DOC19/707163

No Variation to Recommended Comments for Approval - Concrush – SSD 8753

Attachment 1 – EPA response to the Second RtS – SSD 8753

Figure 5 Mitigation measures for normal operation (full operation, weekend operation, and green waste scenarios)

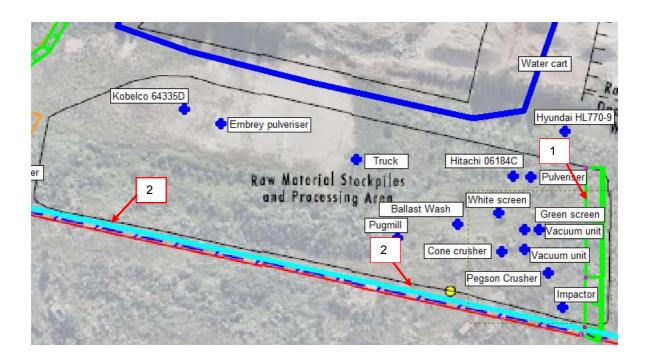
EPA Comment 8: Noise barriers on the eastern and southern perimeter of the premises must be completed prior to the commencement of construction and must be maintained during operations.

Second Response to Submissions: Section 6.2.6 of the EIS identified that no residences will experience noise levels above the relevant criteria during the construction phase. The construction noise predictions did not include mitigation from noise barriers on the eastern and southern perimeter of the premises as these are proposed for the operational phase. The noise barriers on the eastern and southern perimeter of the premises will be established during the construction phase and as such will not be completed prior to the construction phase.

The EPA acknowledges that the EIS did not identify noise levels above the relevant criteria during the construction phase. Despite this, the EPA does not vary this comment as a precautionary measure to assist in mitigating any possible construction noise from the premises.
